CITY OF ALBUQUERQUE

March 3, 2017

RE: **Galles Chevrolet Grading Plan- For Foundation Permit Only**
University and Candelaria
Engineer's Stamp Date 1/27/2017
Hydrology File: H15D065

CN-101

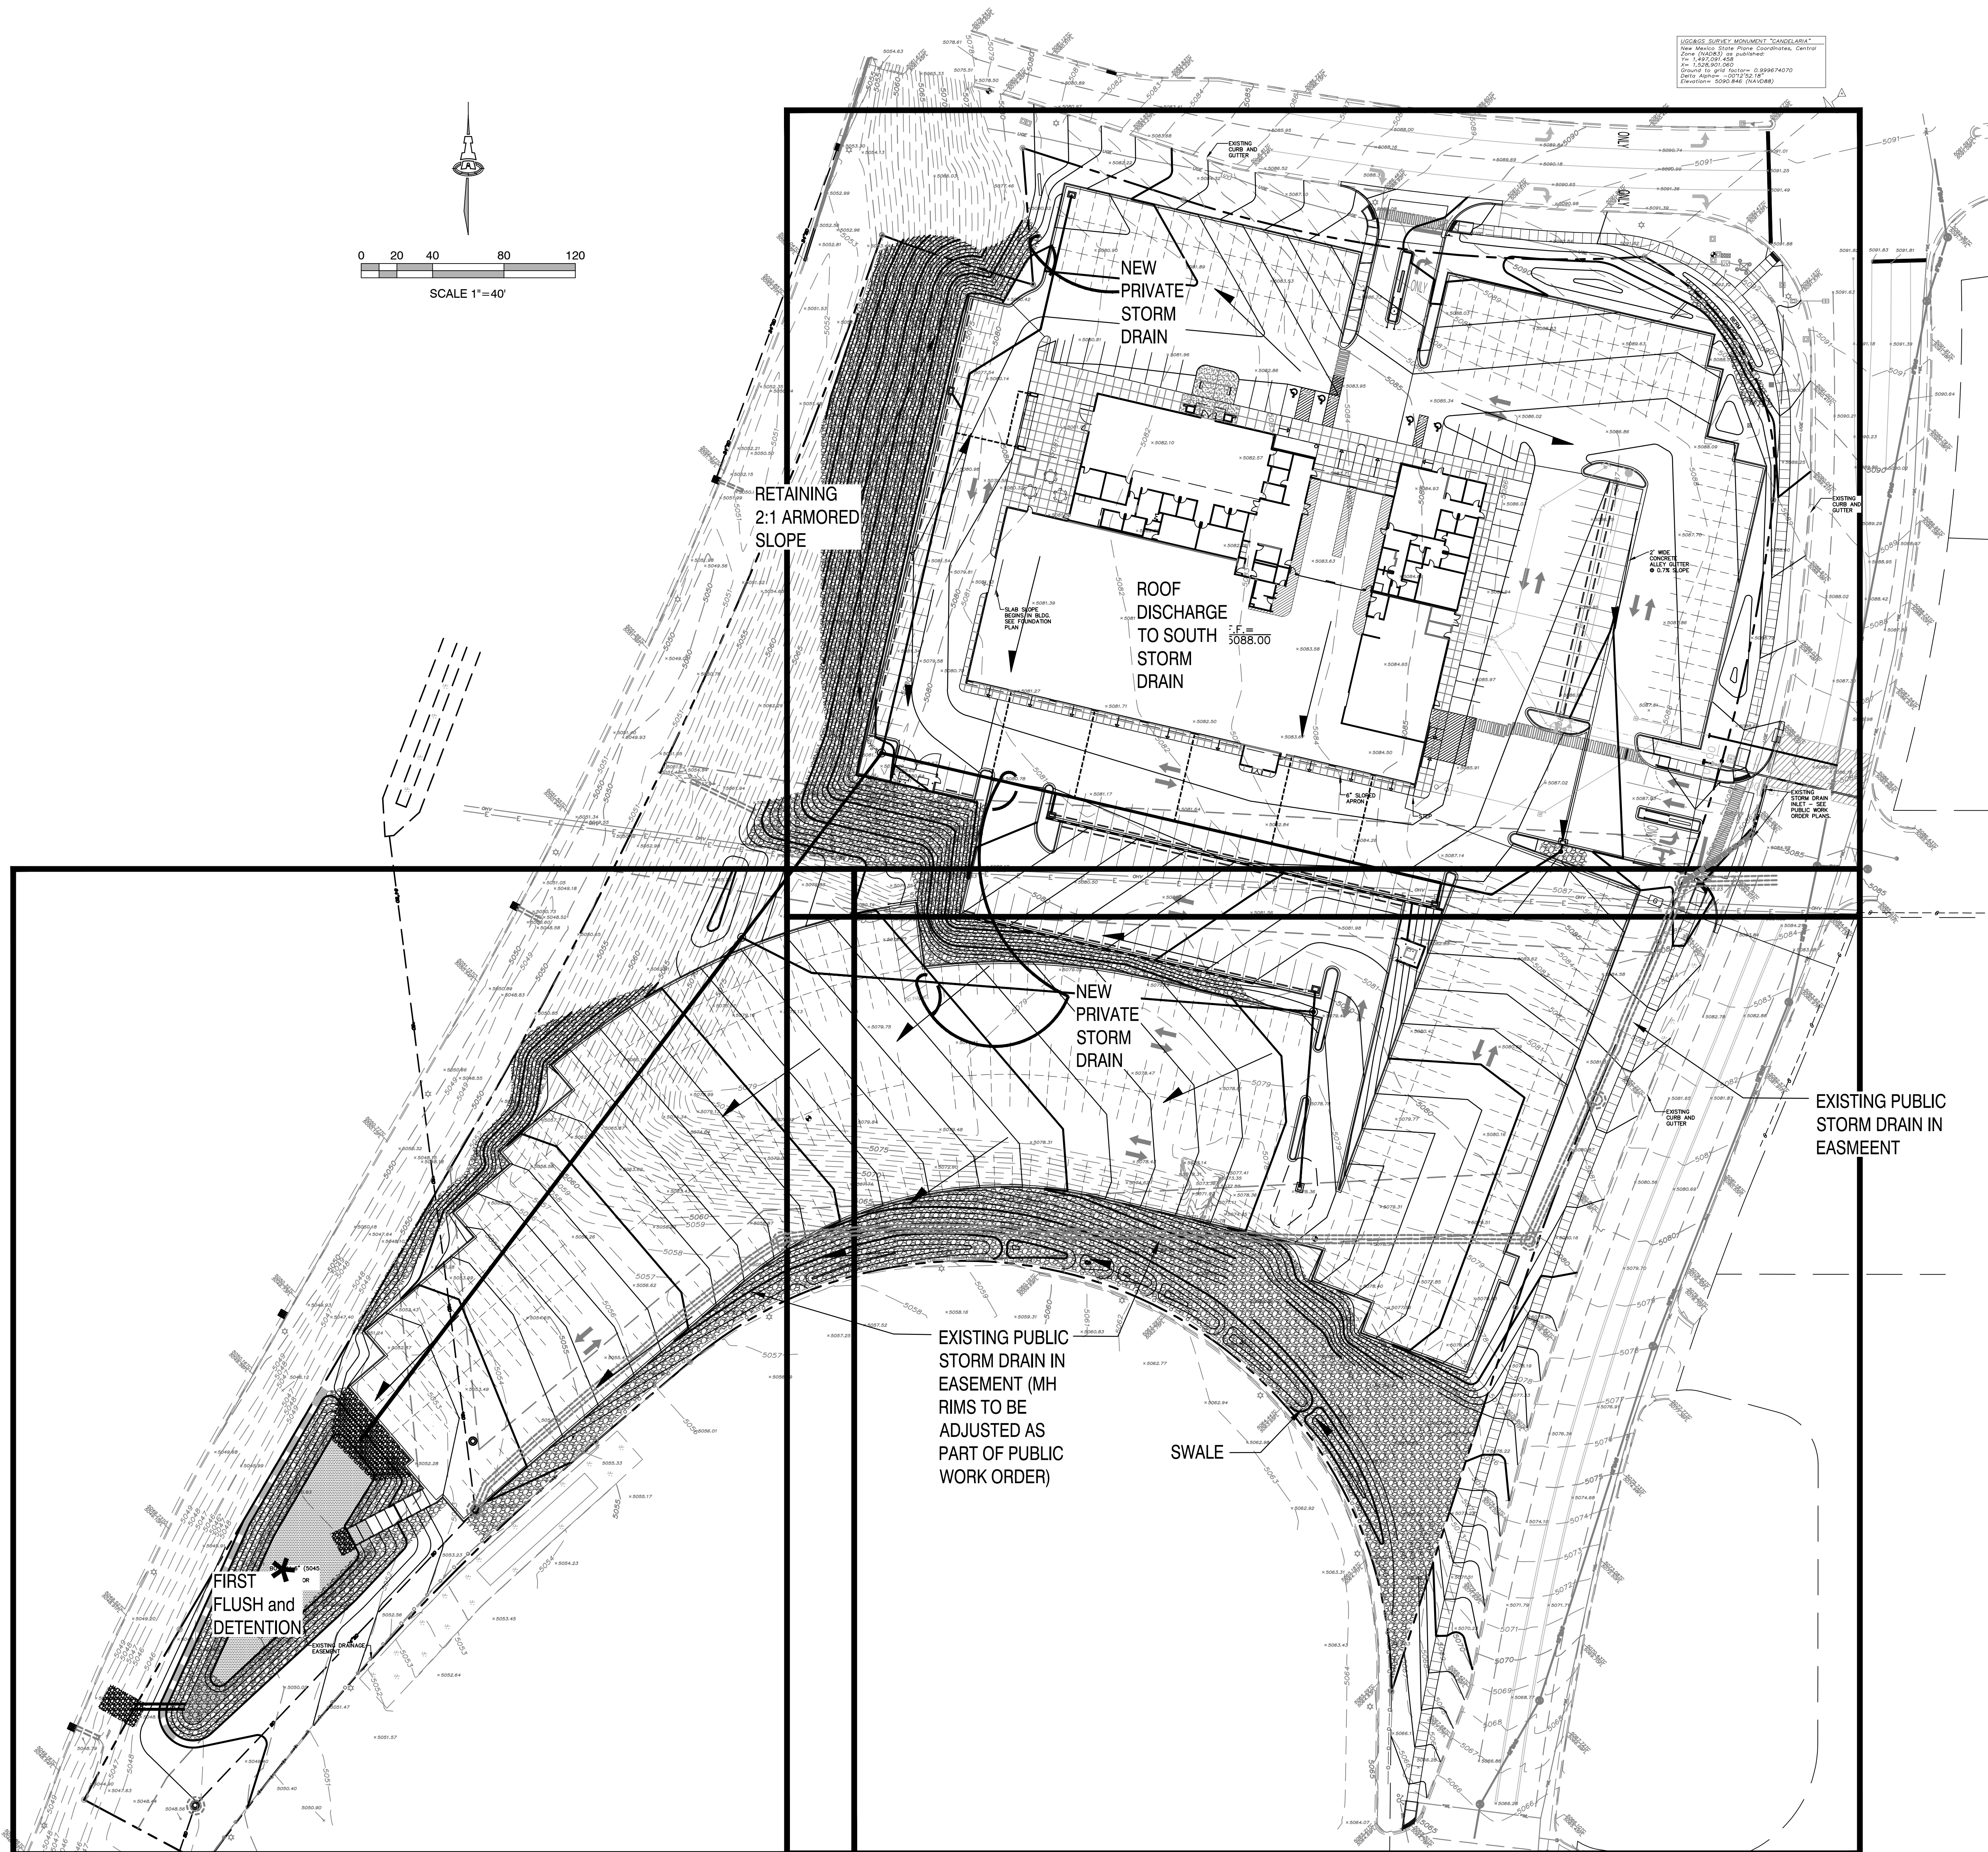
- a. Update the drainage calculations to reflect Precipitation Zone 2, not Zone 4.
 - b. For the building permit set, remove all references to foundation permit only.
 - c. If an SO-19 permit is requested, the standard SO-19 language will need to be added to the sheet and two grading plansets will need to be submitted.
 - d. Is there still a first flush ponding area in the northwest corner? In not, remove the reference to it.
 - e. Additional detail is needed for the retaining walls. Provide section cuts and details for all retaining wall cases. Clarify labeling or add a legend to make it clear what's a retaining wall and what's a header curb or garden wall/fence.
5. Public ROW items. The following items in the city's ROW will need to be addressed for Building Permit, if using SO-19, or Work Order approval, if using a mini-work order.
- a. Provide quarter points for the entrances.

- b. Call-out a 5:1 depressed swale between back of curb and sidewalk. This may already be present per the contours, but should be explicitly called out.
- c. Provide Top-of-Sidewalk elevations and contours along University, north of the entrance.
